**ADC Planning Consultation
Response from the Conservation Officer**

Application Number	BR/72/15/L
Address	Charlotte House, 65 Upper Bognor, Bognor Regis
Description	Application for listed building consent to replace & refurbish 6 No. windows on South elevation.
Case Officer	Mr. R. Temple

South Elevation

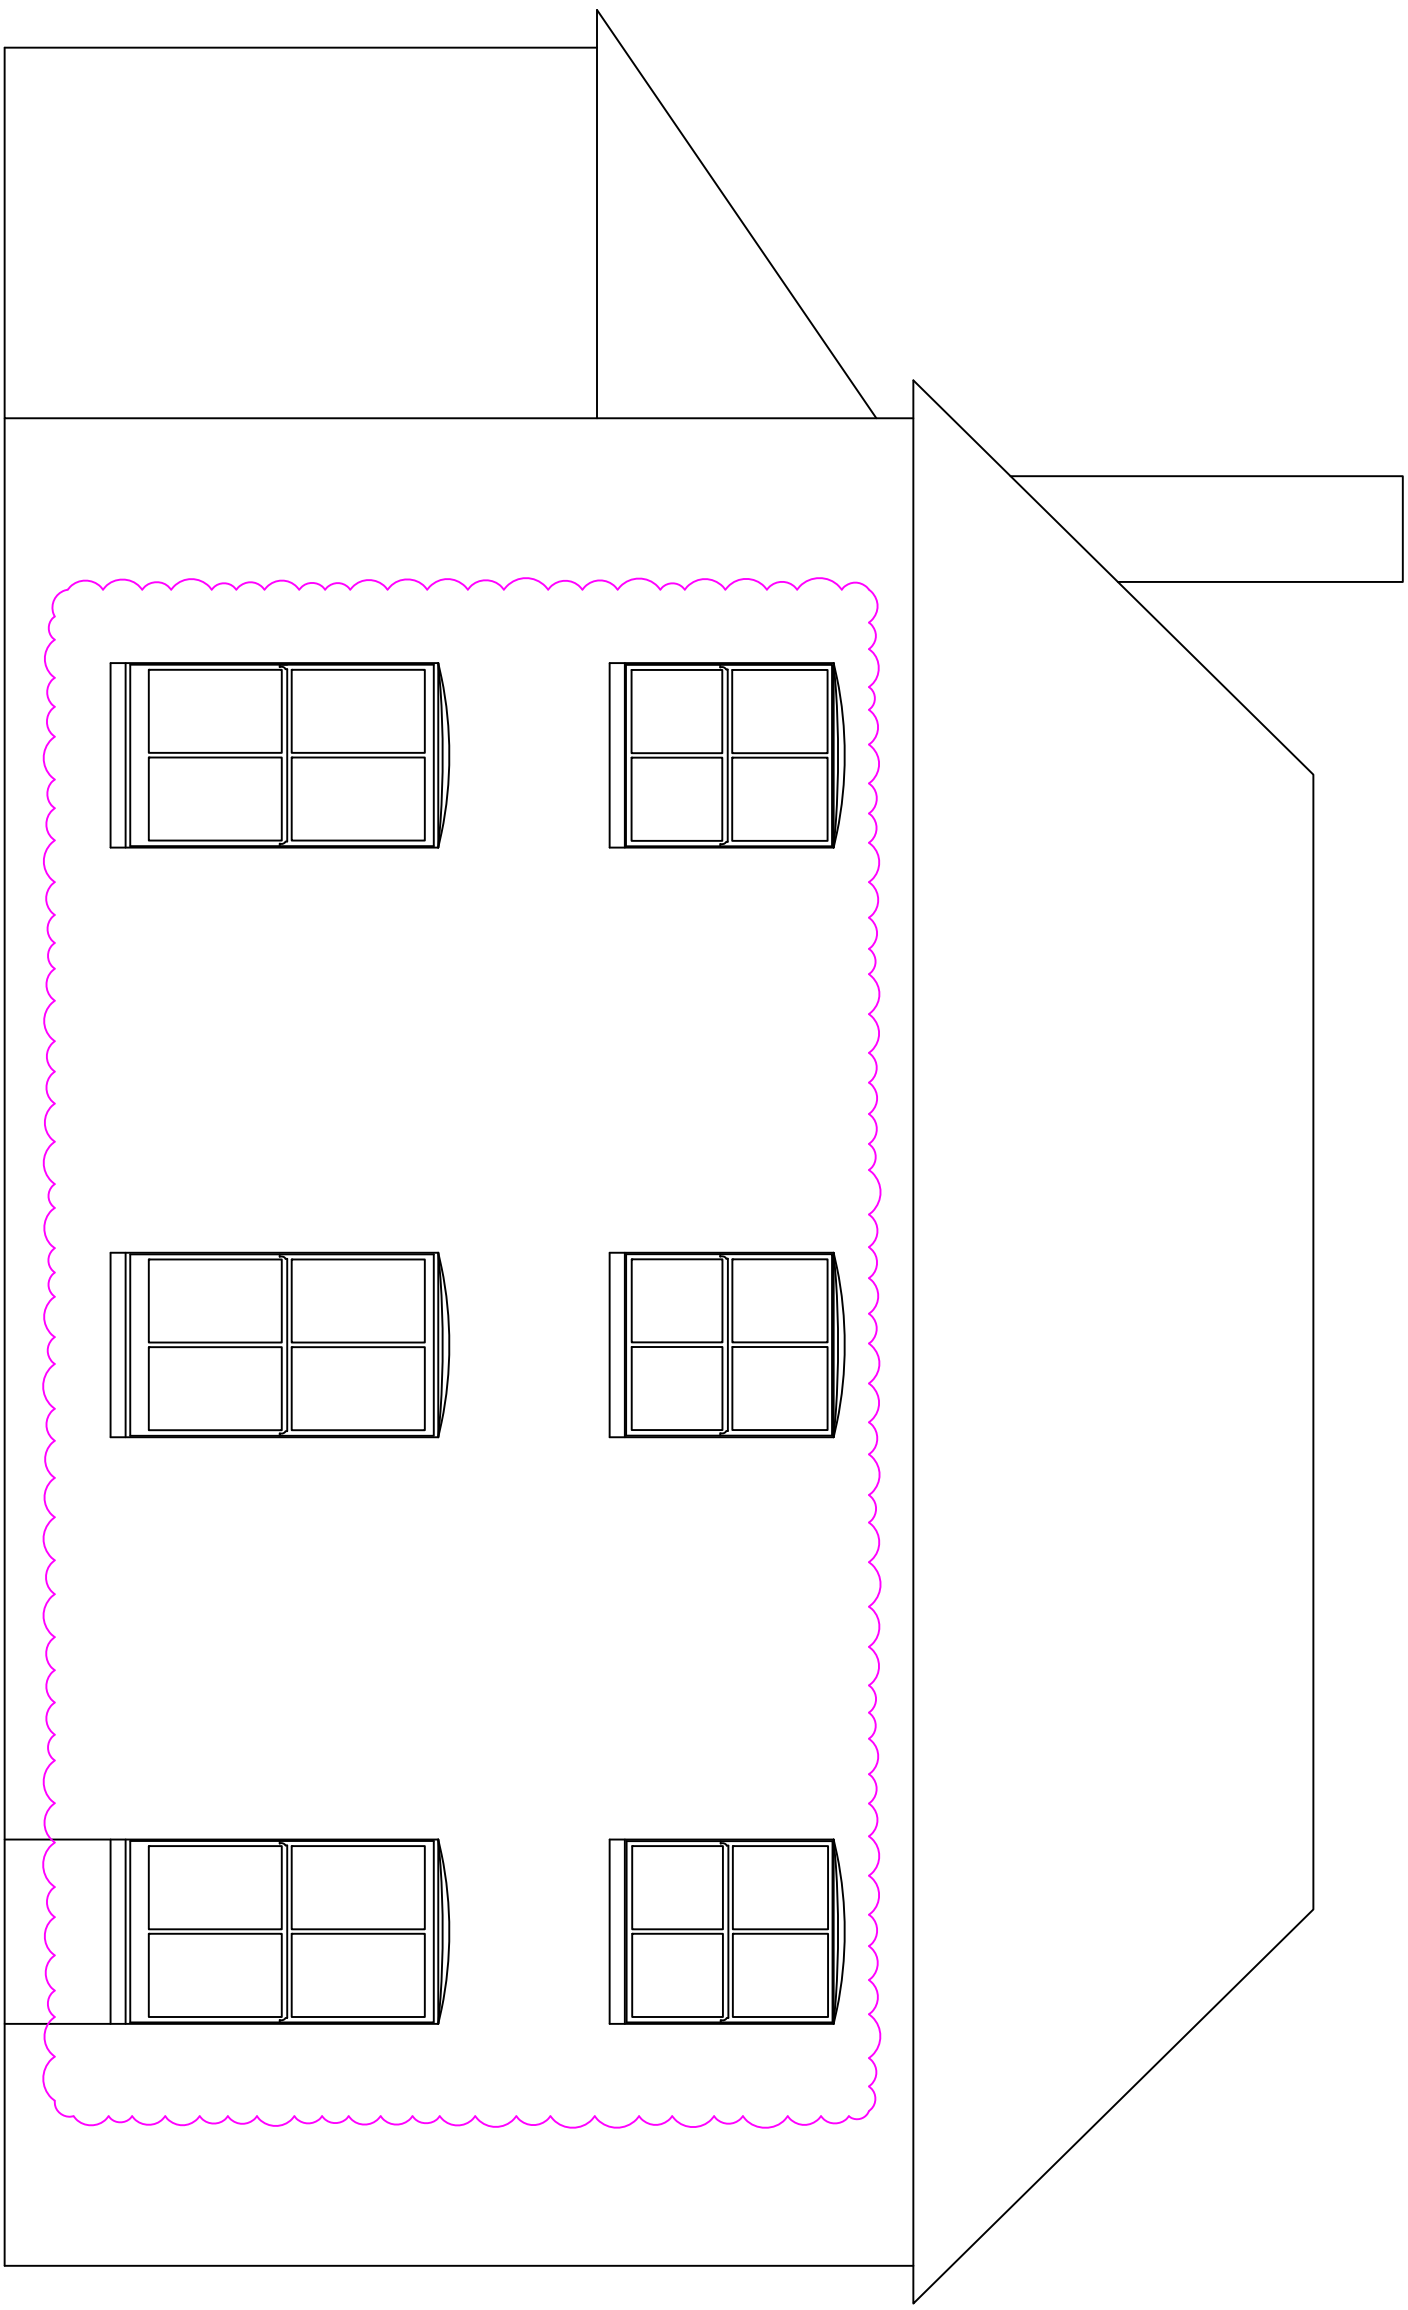
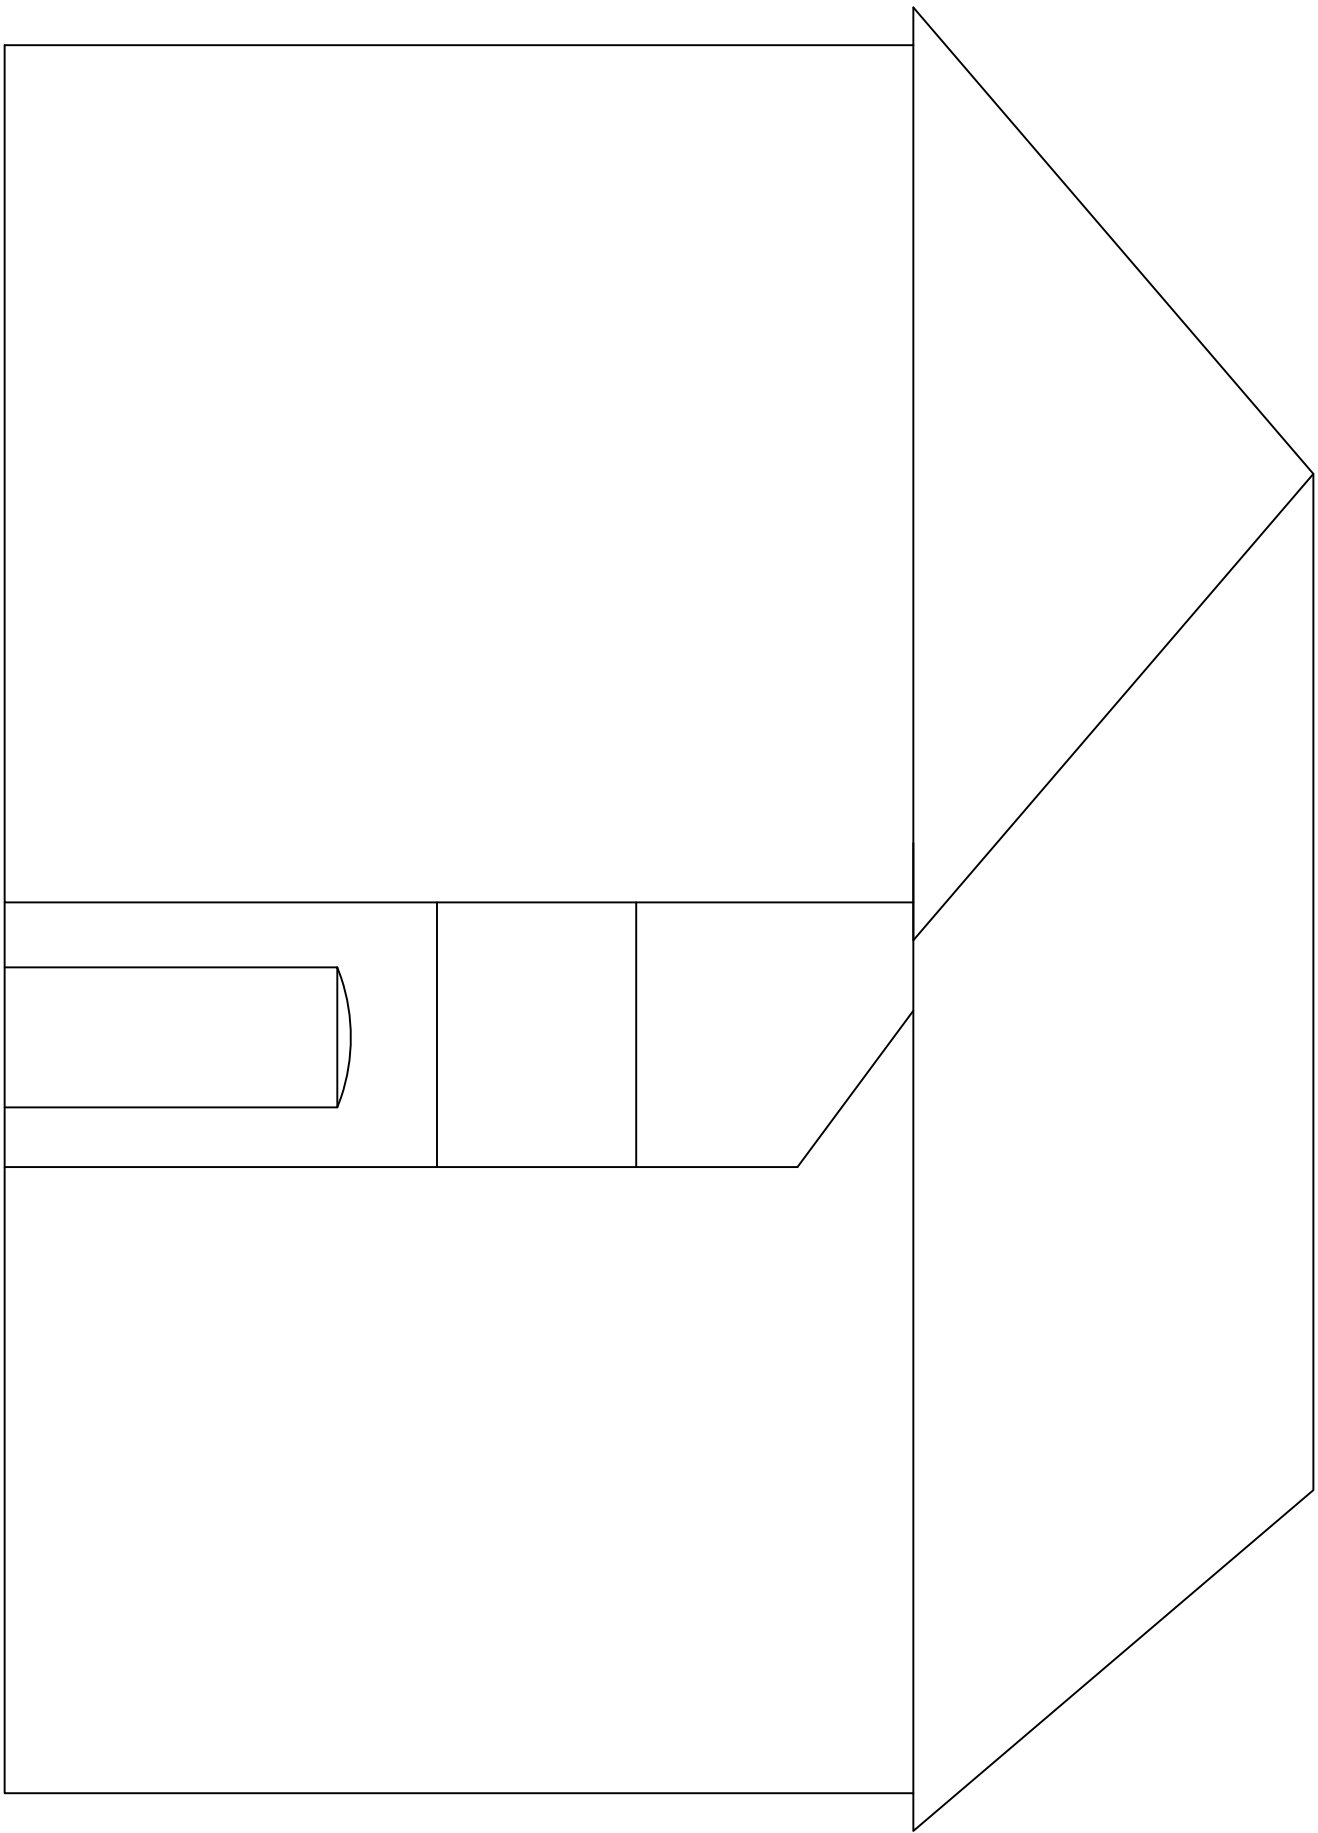
It is considered that the proposal will have a neutral impact upon the conservation area. This is on the basis that the existing windows are in poor condition and beyond repair. Further, that the replacements will be 'like for like'.

It is also assumed that the windows will be (re)decorated to match the existing colour?
